My Ref: AW/40/12-1-25Kingsway

19th March 2012

Ref: Planning Applications: AW/40/12
25 Kingsway, Craigweil House Conservation Area

proposed roof plan

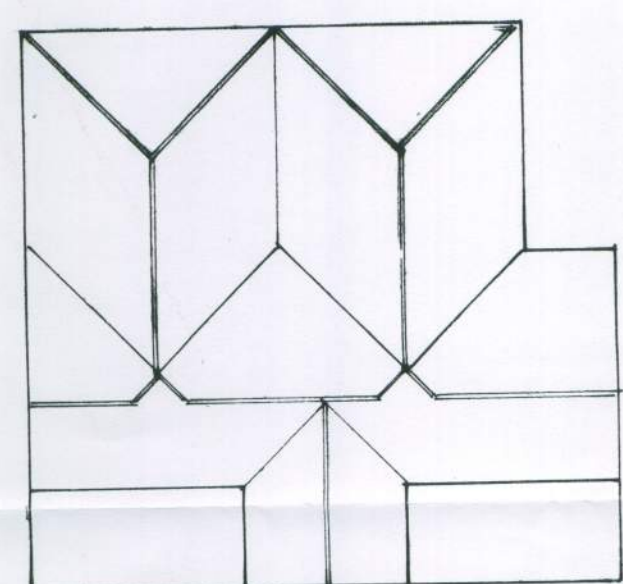
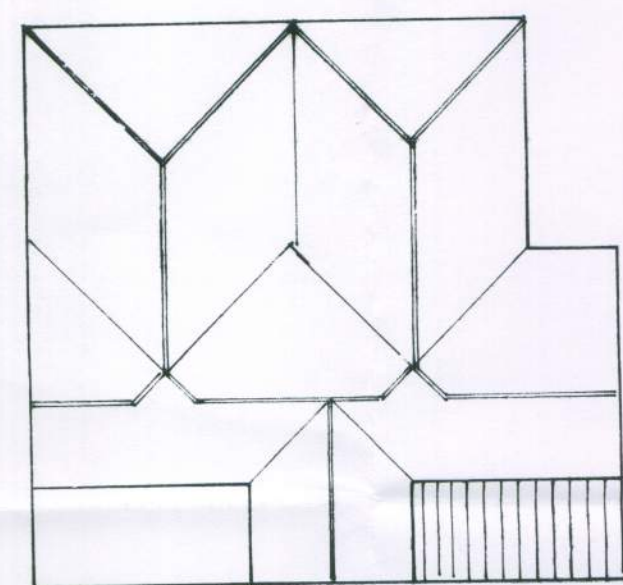
I am not entirely convinced that the introduction of a second style/type of roof tiling is conducive to good design. Apart from the contrast in colour between the existing main roof tiling and the so called 'cat slide' tiling section over the garage frontage, the smooth texture of the proposed Redland Stonewold 11 tiles will add to the incongruous appearance of the two. The 'cat slide' will be introducing a horizontal feature across the front elevation that is not 'balanced' as in the existing scheme. Similarly, balanced against the opaque glass (pale coloured) on the other side of the elevation, it will not sit well in the general scheme of things. I submit this would not be an acceptable suggestion in the Conservation Area where quality design features are sought in both new and altered property.

sheet 2 of 2

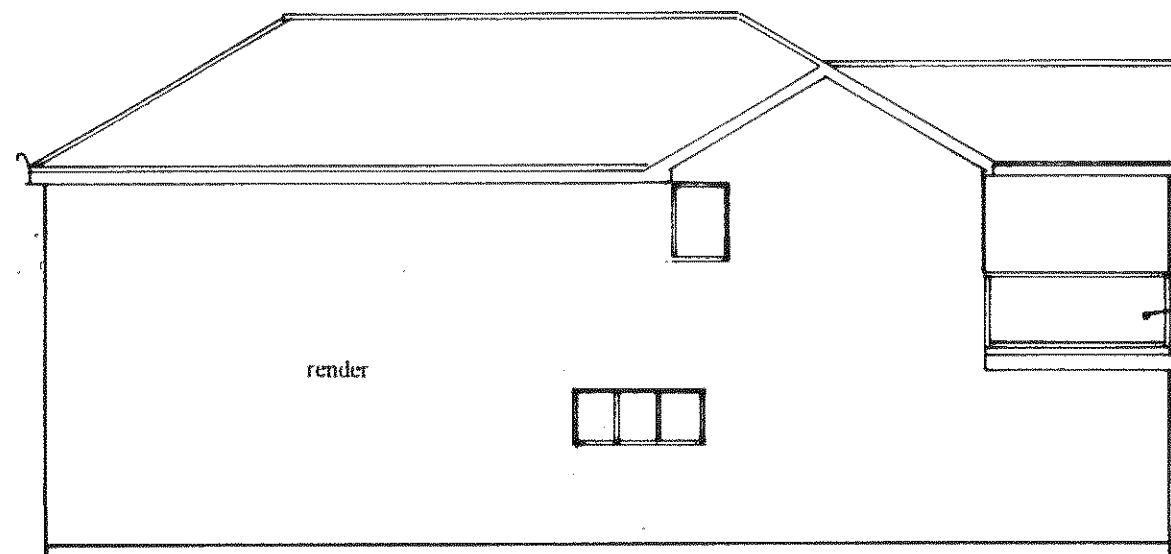
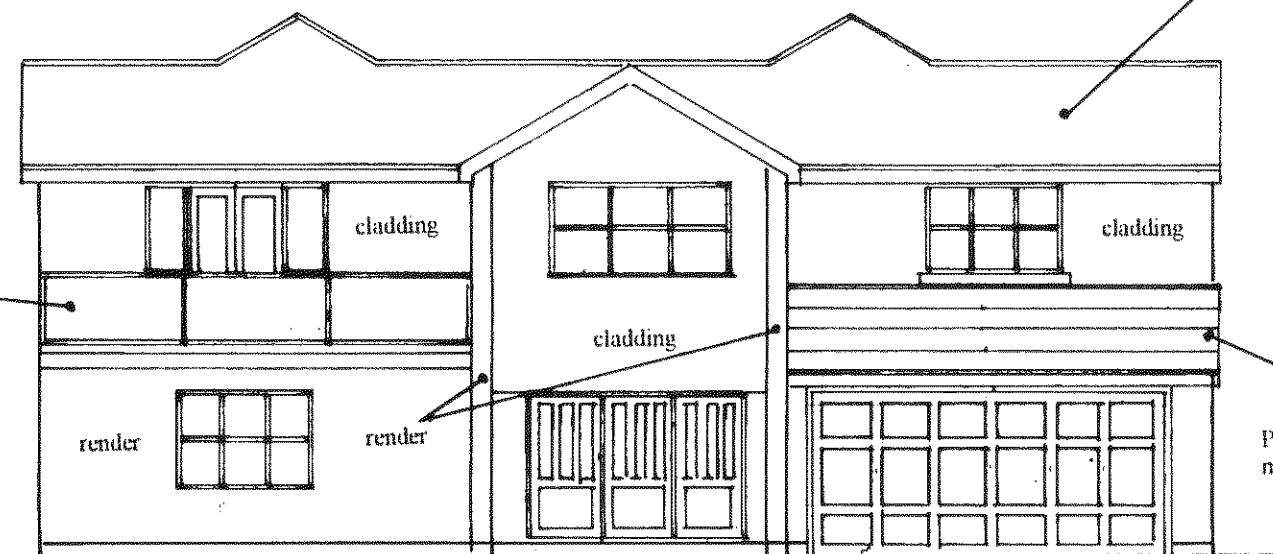
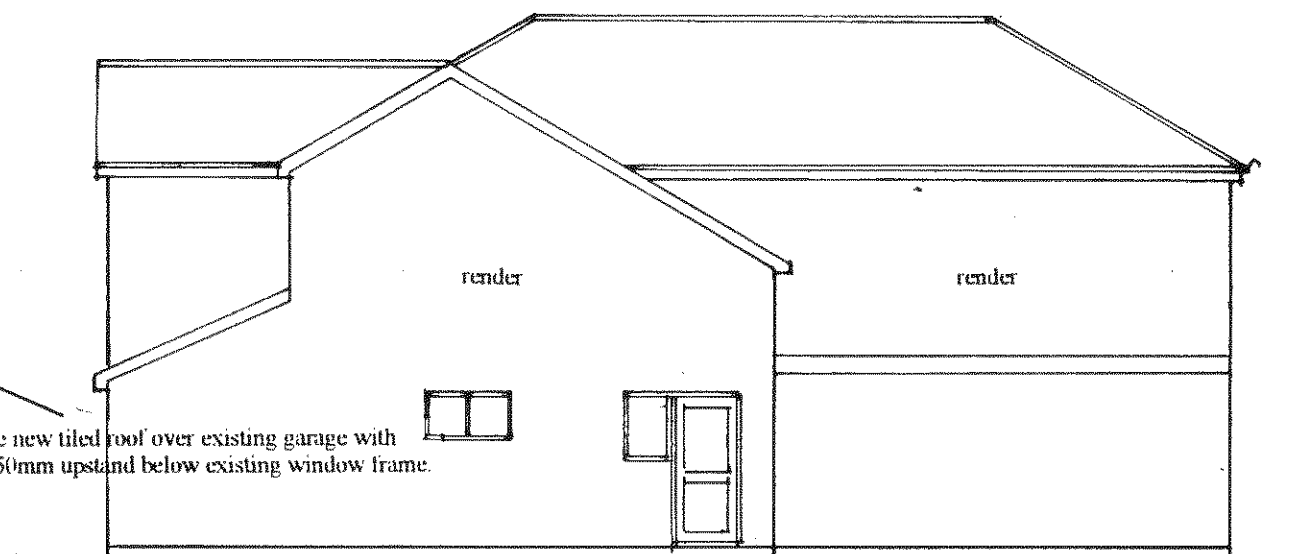
To change from the red/brown coloured brickwork to the 'cream' selected will completely change the appearance of this house, out of character with what exists and with its neighbours. More importantly, the proposals cannot surely Preserve or Enhance the Character of the Conservation Area. This too, for **ALL ELEVATIONS**, North, South, East and West.

There is then the proposal for replacing the black, wrought iron balustrade to the balcony front at first floor level on the main, south elevation, with stainless steel and opaque glass infill panels. This too will be a completely unsympathetic and unprecedented change of appearance and not complementary or an improvement to the Conservation Area. This period of property is not conducive to such modern treatment in this environment. Such detailing will adversely dominate the front elevation and street scene, compared with the present arrangement which 'retires and blends' into the character of the building.
